EL PASO COUNTY GRADING AND EROSION CONTROL CHECKLIST

EPC Project Number: **VR262**

7886 RANNOCH MOOR WAY
 GRADING, EROSION, & SEDIMENT CONTROL PLAN

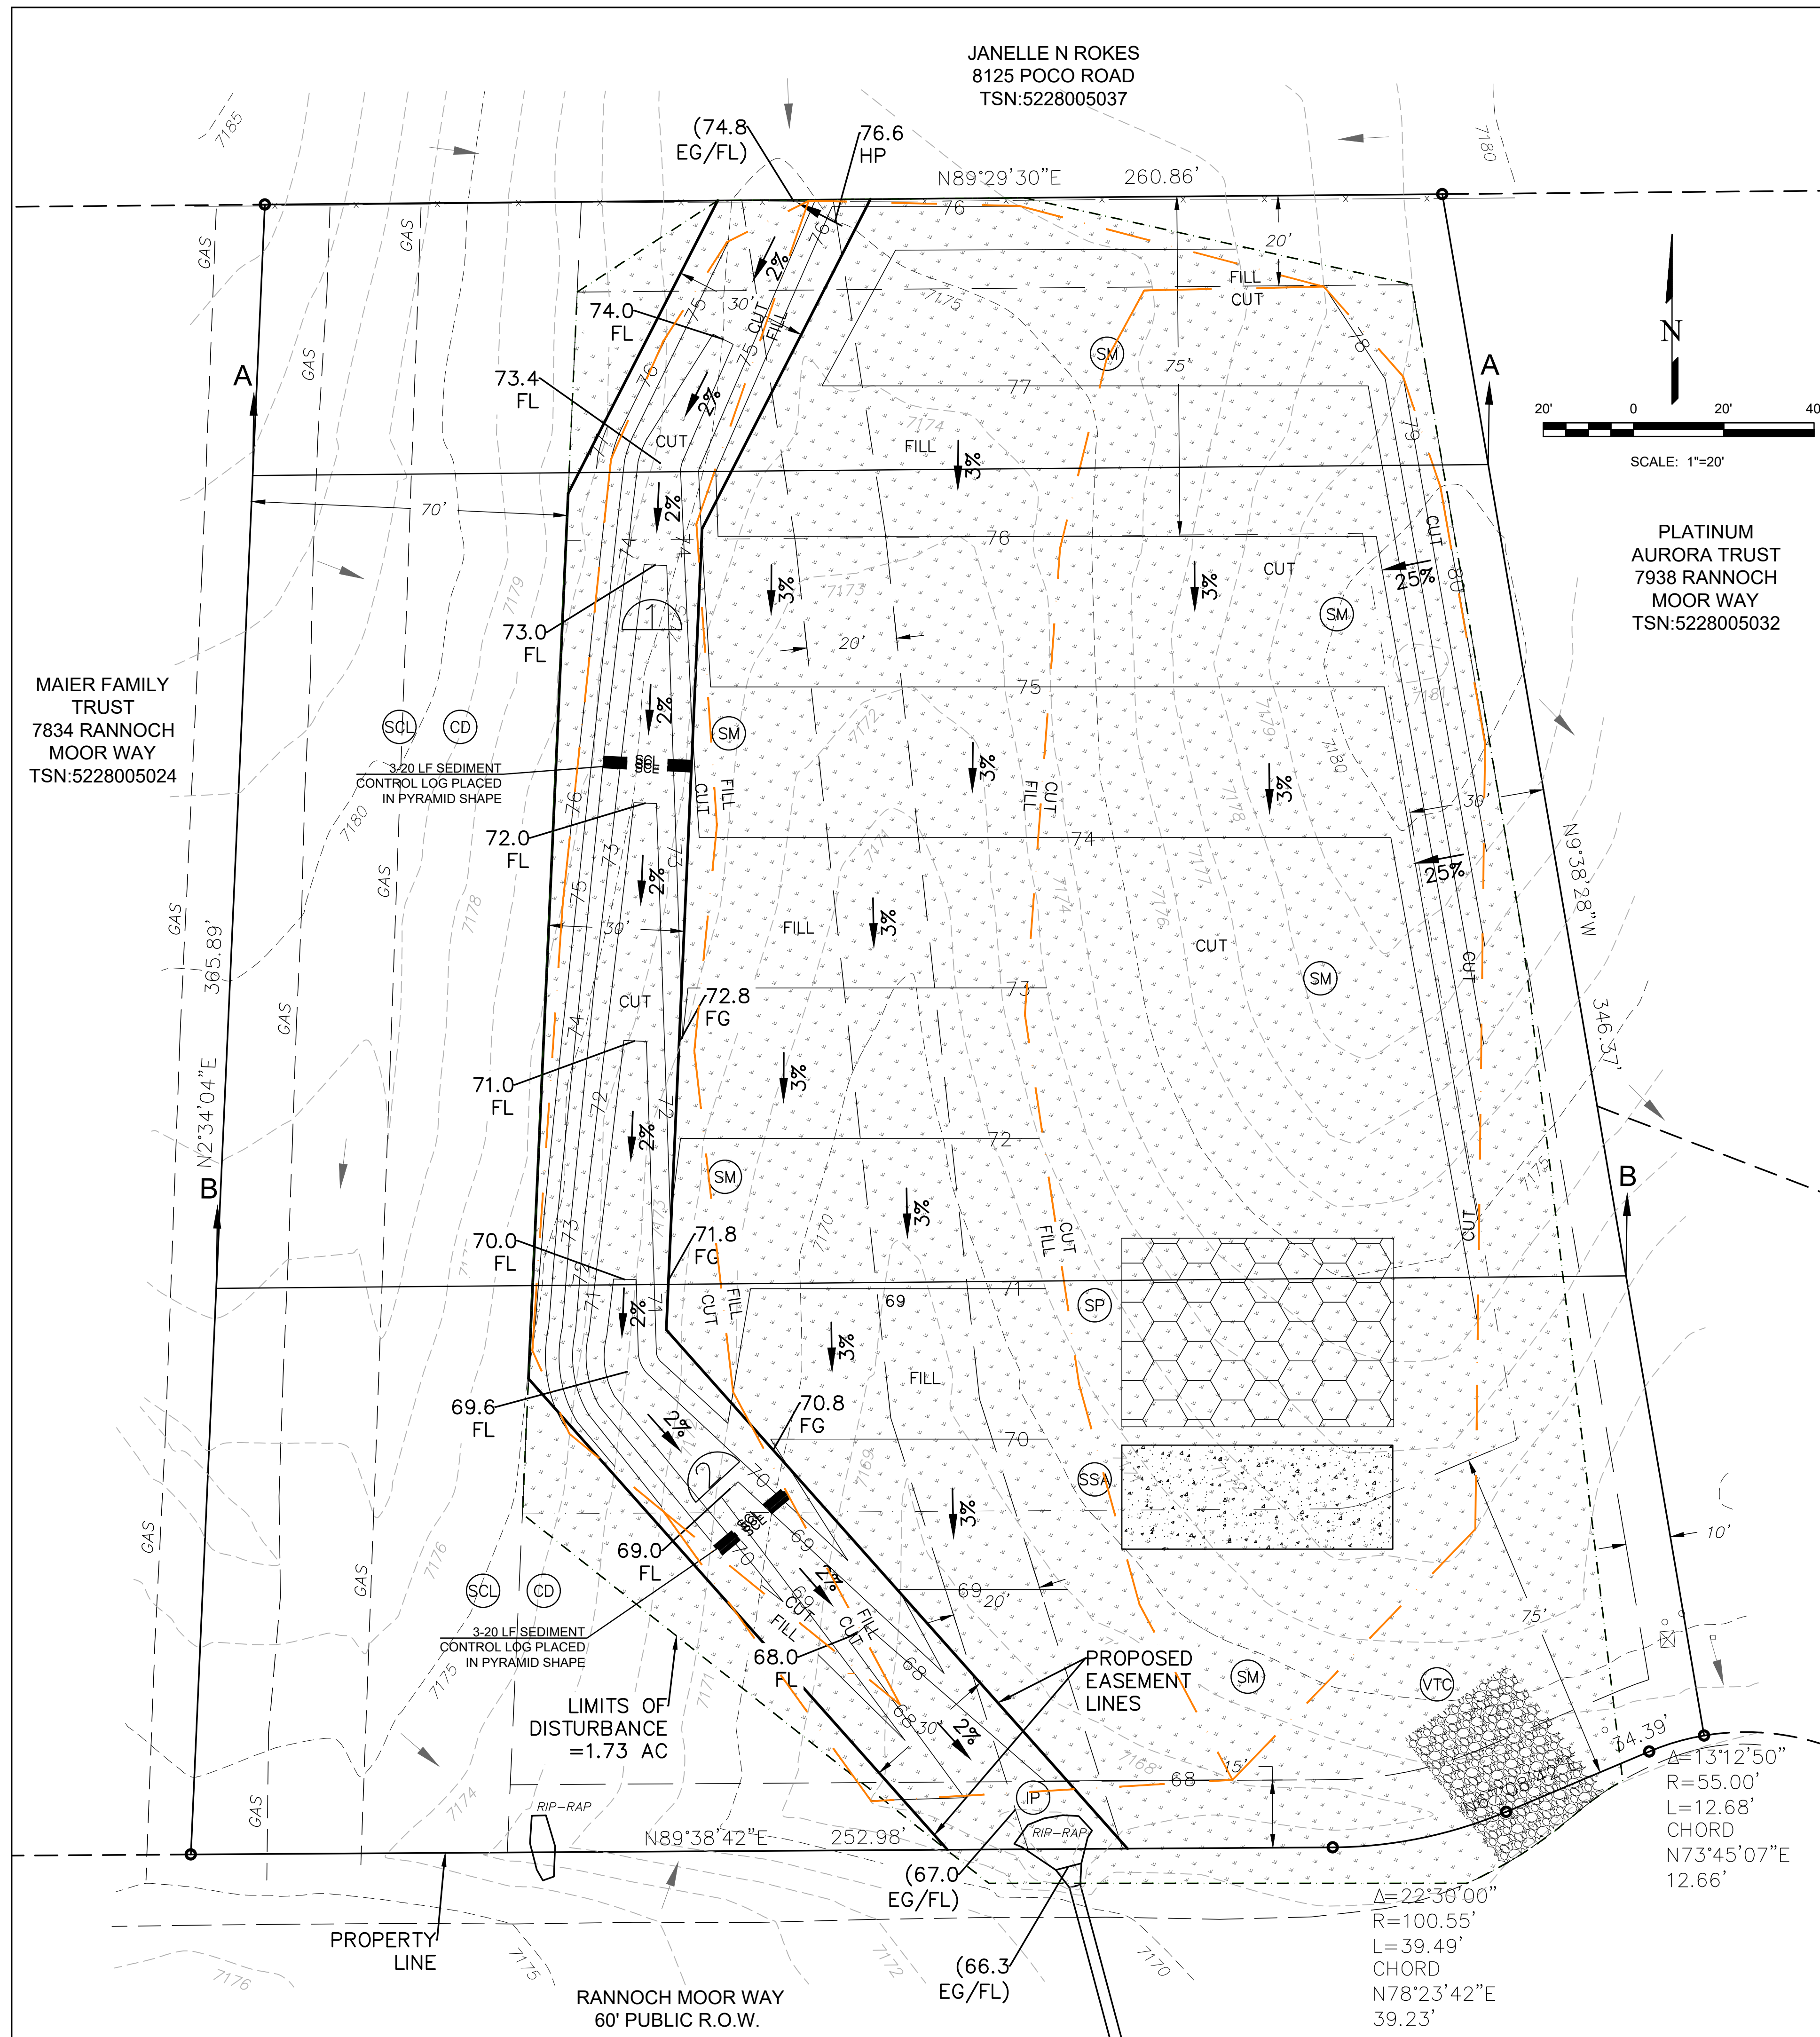
K	Existing vegetation (notes are acceptable in cases where there is no notable vegetation, only grasses/weeds, or site has already been stripped)		Y
L	Proposed construction site boundaries and limits of disturbance. Show each as separate line types on the legend and map, unless they are the same, then show as "limits of disturbance and limits of construction site"		Y
M	Existing and proposed contours 2 feet or less		Y
N	Existing and proposed flow arrows depicting stormwater flow directions on and off-site		Y
O	Proposed areas of cut and fill		N
P	All proposed temporary construction control measures, structural and non-structural. Temporary construction control measures shall be identified by phase of implementation to include "initial," "interim," and "final" or shown on separate phased maps identifying each phase		Y
Q	Proposed slopes steeper than 3:1 with top and toe of slope delineated. Erosion control blanketing or other protective covering required		N
